CITY OF ALBUQUERQUE

April 20, 2018

**Re: Generations at West Mesa
Erosion and Control Plan
Engineer's Stamp Date –no date, No NM Registration- (K11E084)**

EROSION AND SEDIMENT CONTROL PLAN

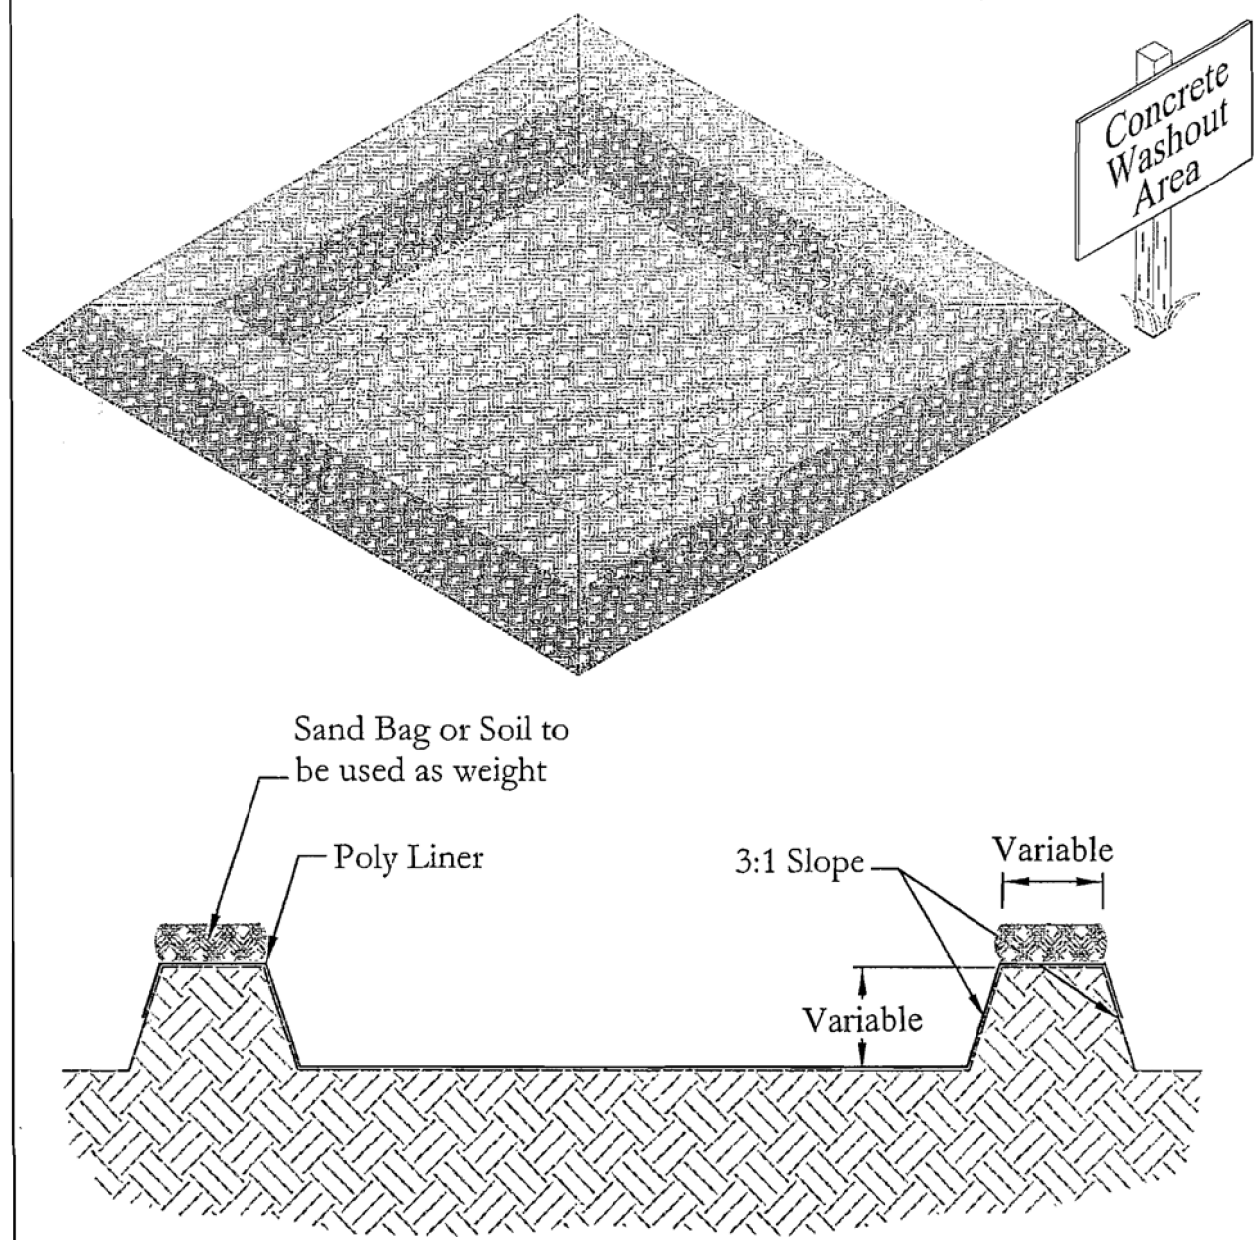
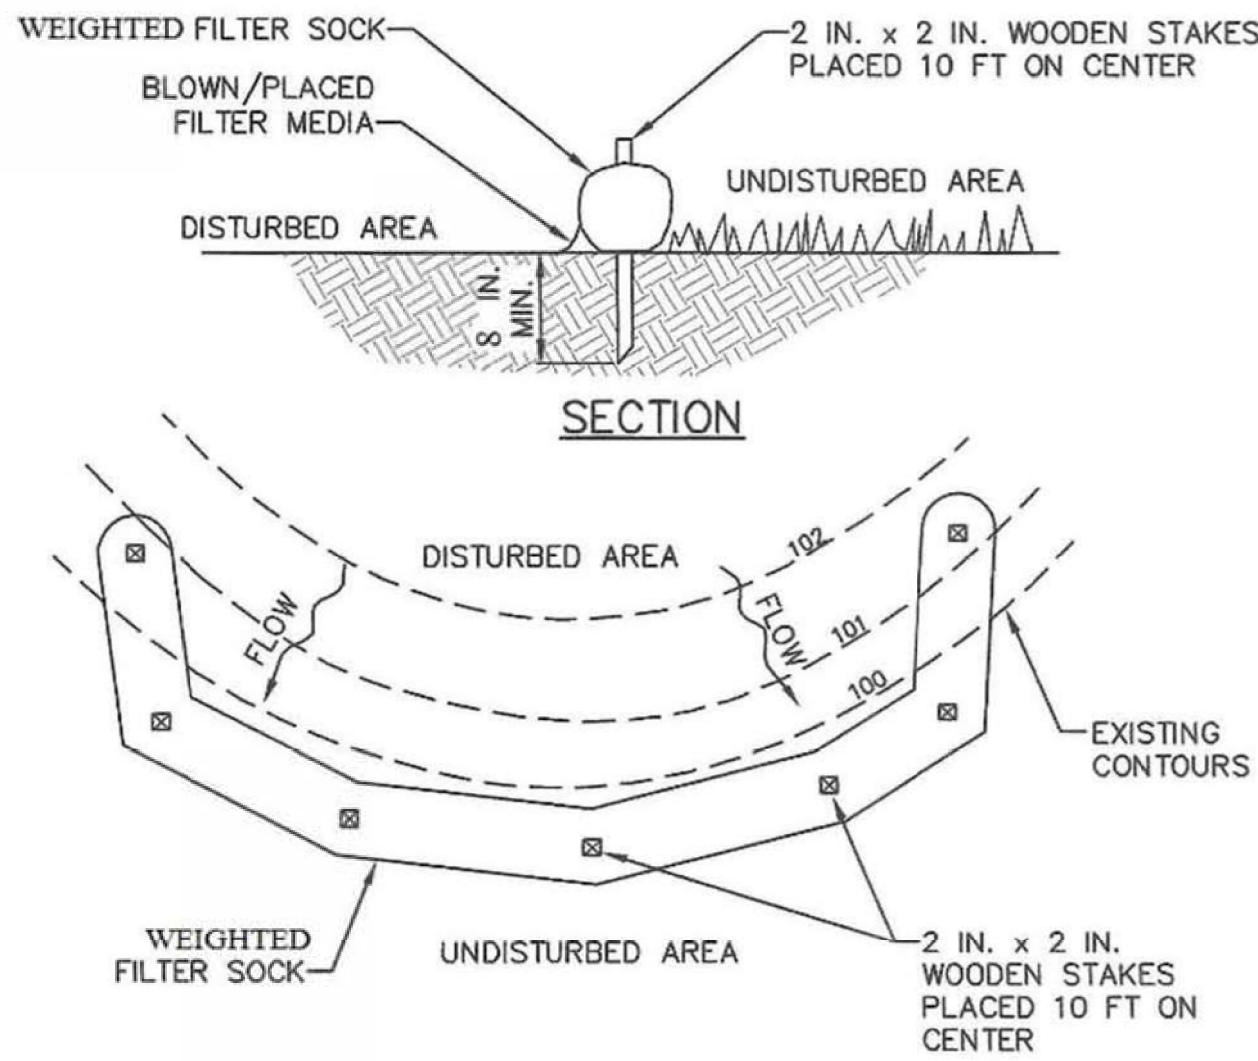
1. The plan is to be stamped and sealed by a Professional Engineer registered in the state of New Mexico.
2. Provide proposed grades.
3. Provide inlet protection for the inlet near the southeast corner of the site.

4. Provide details for all proposed BMPs.
5. As a minimum, the two large first flush ponds shown in the south area of the site are to be graded with the initial grading. Please indicate this on the plan.

6. Provide a Vicinity Map. This is a small (4"x 4" or so) window on the plan that shows the location of the site.
7. It would be preferable to locate the construction entrance on Avalon as it is the uphill portion of the site. Construction entrances located downhill on a site can require more maintenance as drainage from the site (precipitation/ watering for dust control) can accumulate sediment in the BMP.

8. A fiber roll is an acceptable sediment BMP. However, some operators install silt fence instead, as it is usually required by the City's Fugitive Dust Permit.

9. Please add the note "When doing work in the City ROW (e.g. sidewalk, drive pads, utilities, etc...) prevent dirt from getting into the street. If dirt is present in the street, the street should be swept at the end of each day or during the day if rain is imminent or if the contractor introduces water into the street."

10. Somewhere on the plan, most likely in the Title Block, add a title that this is an "Erosion and Sediment Control Plan" or similar.
